**KIRKLEES METROPOLITAN COUNCIL
INVESTMENT & REGENERATION SERVICE**

**DELEGATED DECISION TO DETERMINE APPLICATIONS FOR
CONSENT, AGREEMENT OR APPROVAL REQUIRED BY CONDITION**

Reference No:	2022/44/92236/E
Site Address:	Field House, 15 Wellington Street, Dewsbury, WF13 1BQ
Description:	Discharge of conditions 3 (detailed drawings), 4 (additional storey), 5 (materials), 6 (residential waste), 7 (A3 use waste), 9 (swift nesting), 14 (ventilation), 15 (noise assessment) and 19 (air quality) of previous permission 2019/92962 for erection of additional storey and conversion of building to provide 23 self-contained apartments and A3 use in basement and part of ground floor (Listed Building within a Conservation Area)
Recommending Officer:	Victor Grayson

Second Officer Report

01 Site Refuse Strategy Plan
Scale: 1:100

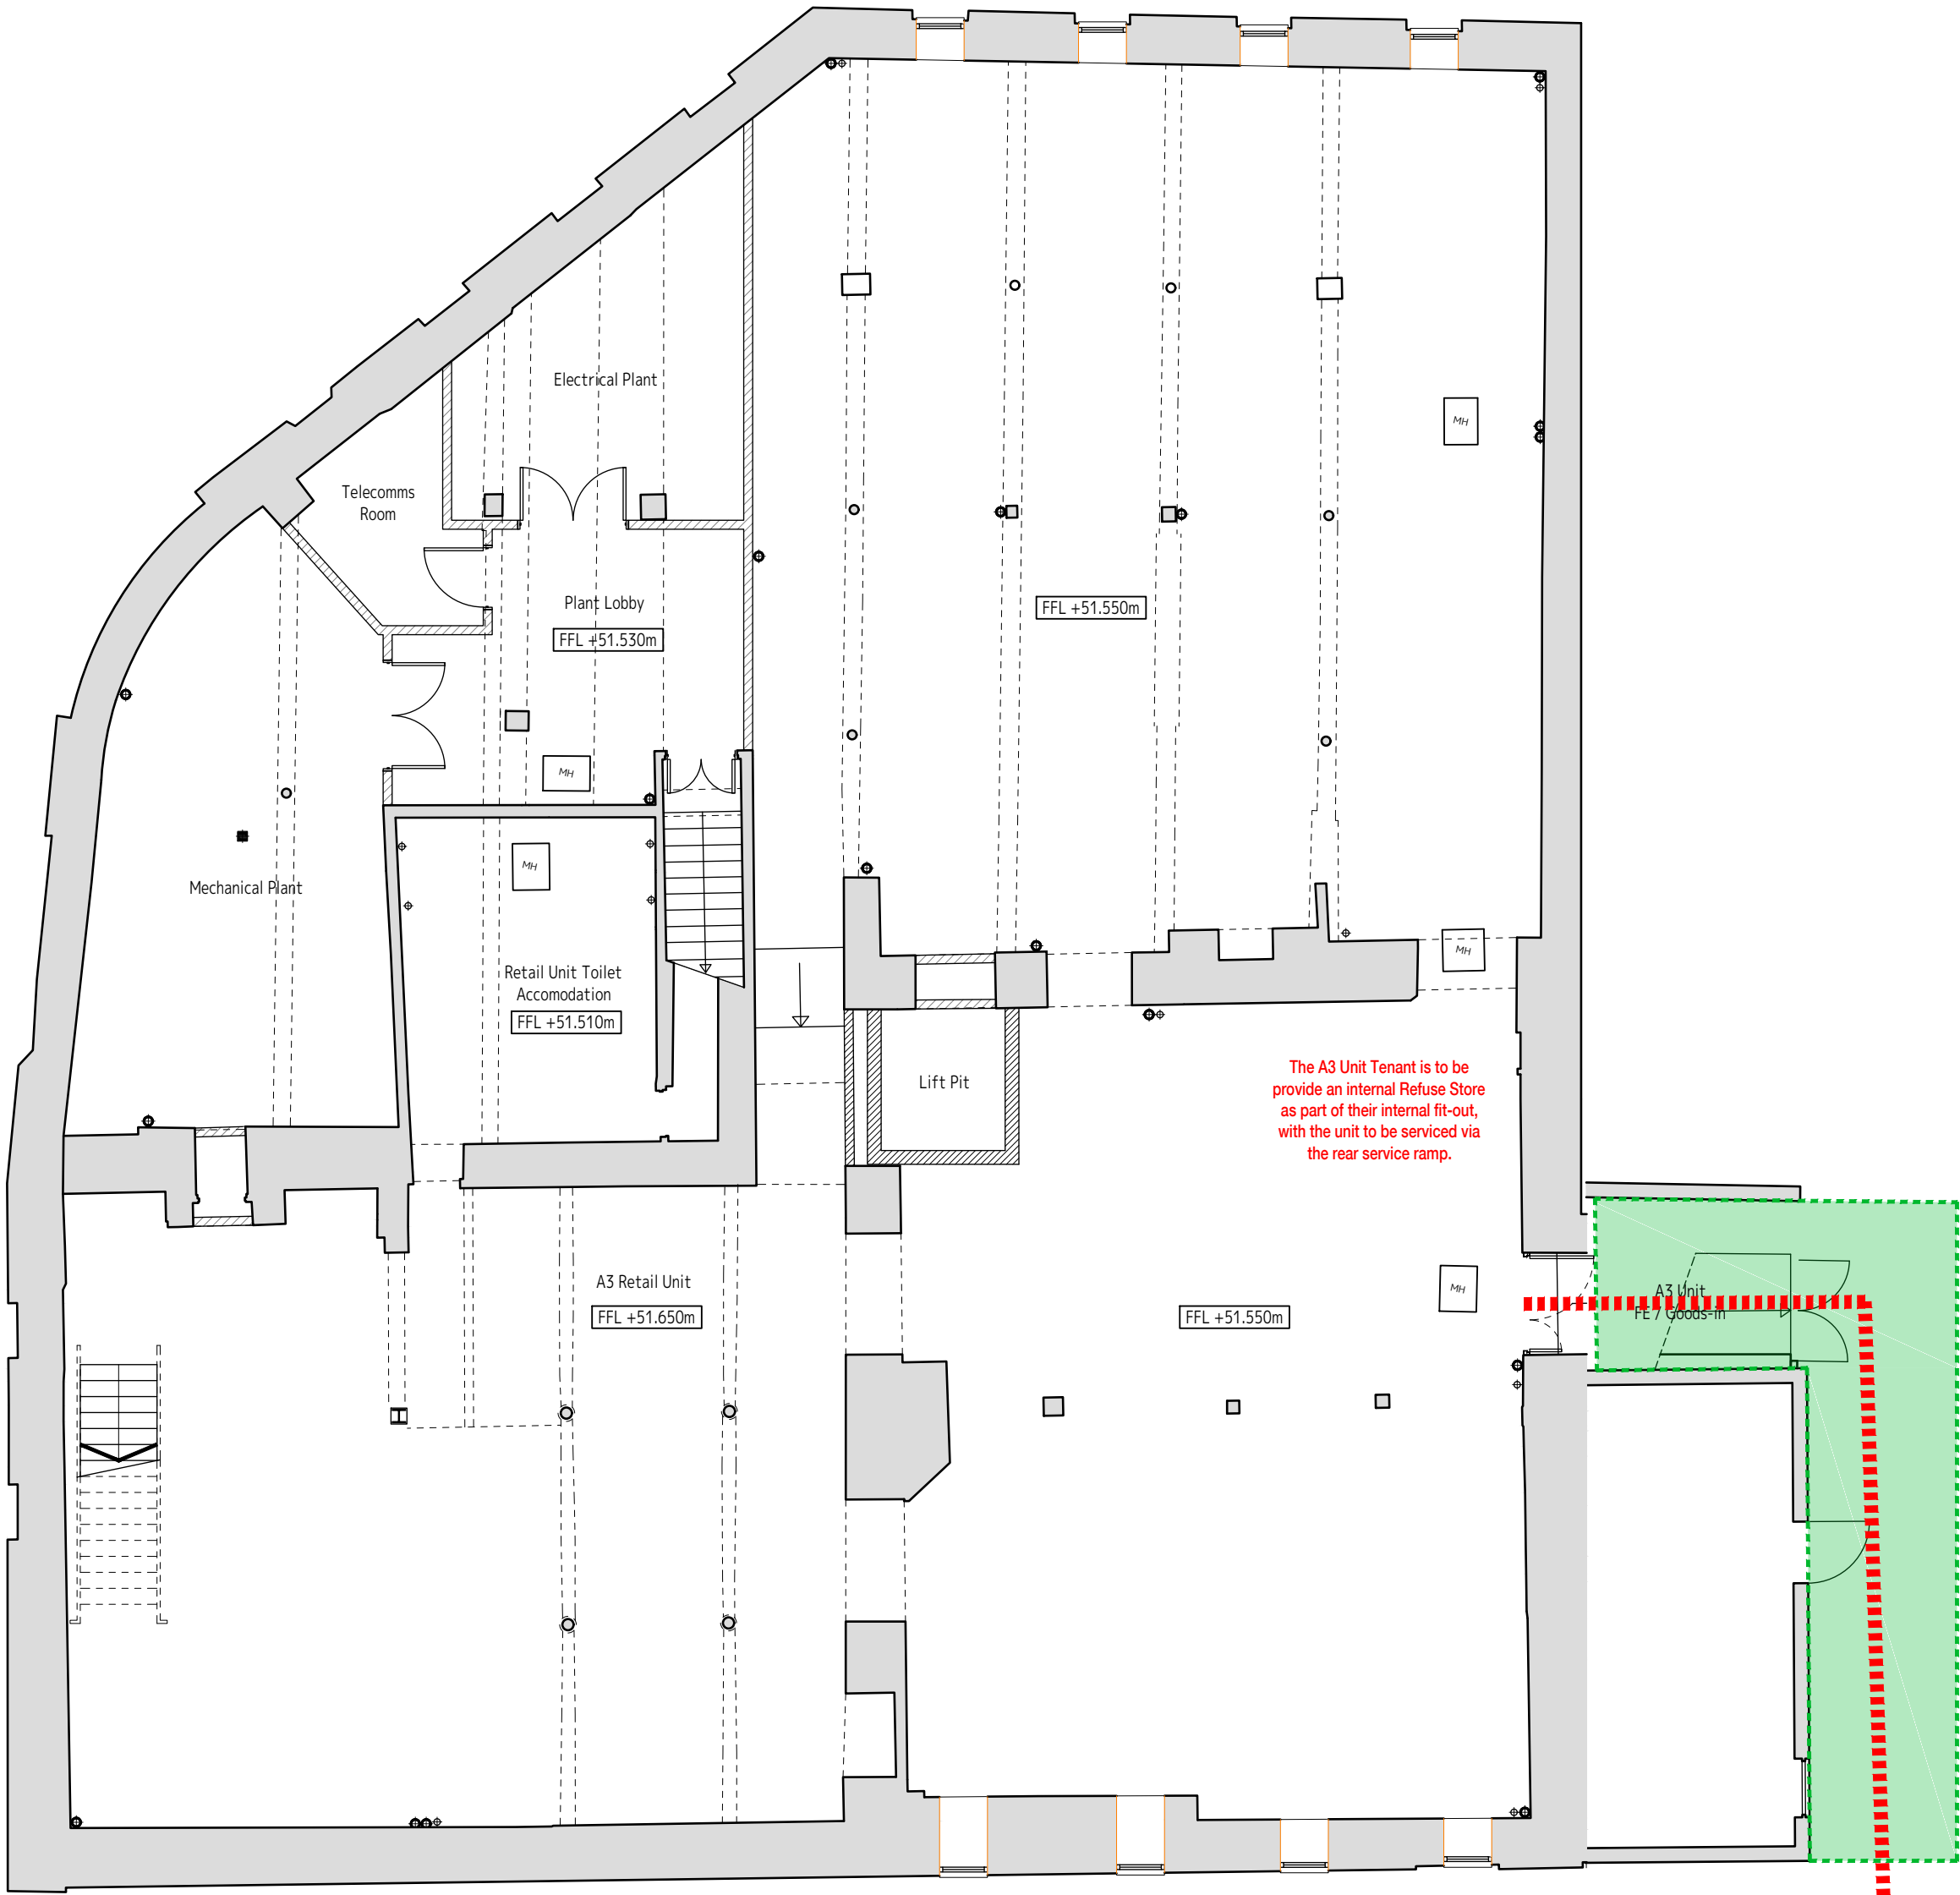
As with condition 6, KC Waste Strategy made initial informal comments, officers met with the applicant team, and an amended drawing (2018-051 0811 rev A titled "Refuse Strategy (A3 unit)") was submitted.

Given KC Waste Strategy's further informal comments of 16/11/2022, it is recommended that the information submitted pursuant to condition 7 be approved.

01 Site Refuse Strategy Plan
Scale: 1:100

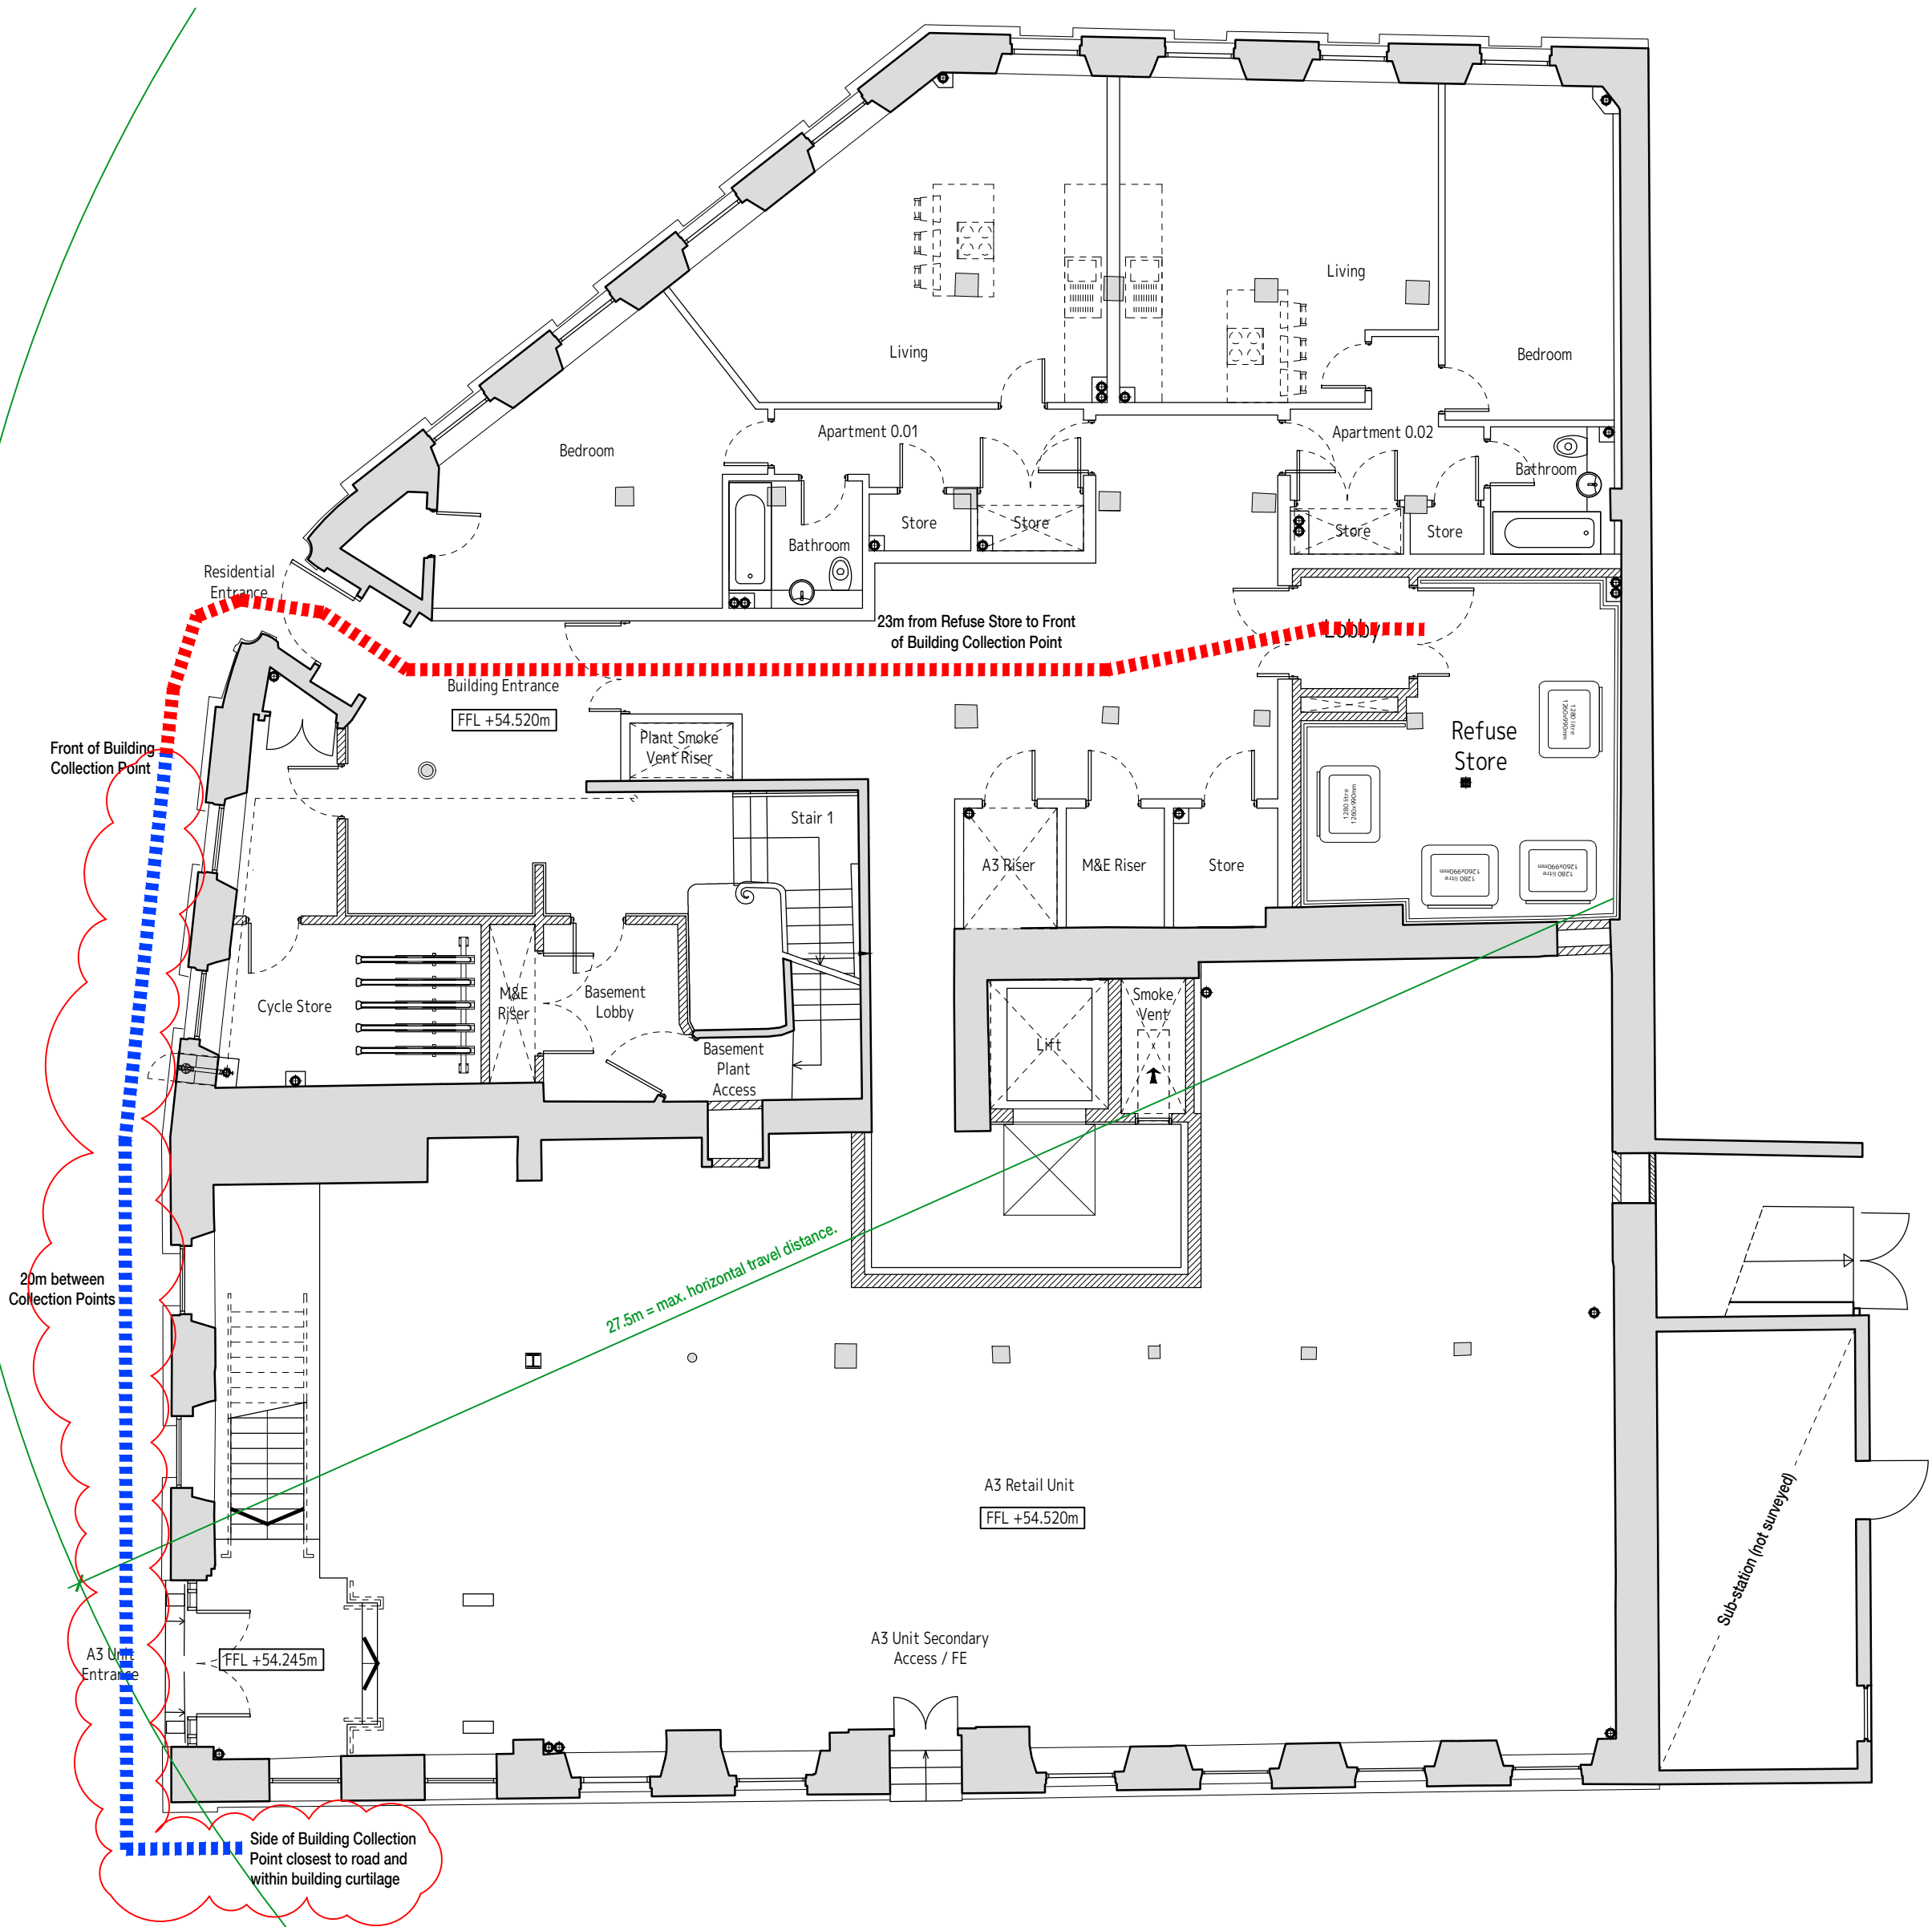
Despite some changes the proposals do not really address the waste issues identified by Carol Oakden in her response to the 2019 planning application e.g. location of store with access through lobby to main entrance and then no close location for access of an RCV.

The currently proposals include waste storage in the retail unit using a rear access door and ramp that with a change to the internal layout (depending on floor levels) may be a more acceptable solution for the whole building.

This is a difficult site to service and waste issue could be a long term problem if not resolved.

On 04/11/2022, the applicant submitted amended drawing 2018-051 0810 rev B titled "Refuse Strategy (Residential)", and stated:

The new identified collection points to the side of the building will hopefully offer a more discreet location and ease collection as they are nearer to the road/kerbside.

We have marked the routes to the side of the building as additional to the original locations as they are now in excess of 25m but it is agreed they are a better location for collection.

It is also confirmed that the bins will be wheeled out to the agreed collection points and back again by the building management and the tenant for residential and A3 unit waste respectively on the day of collection.

I can confirm that the commitment for the management company / caretaker to be responsible for moving / putting out / returning bins from the internal bin store to a Bin Collection Point on the corner of Wellington Street at the location shown on the plans is acceptable and therefore the conditions can be discharged.
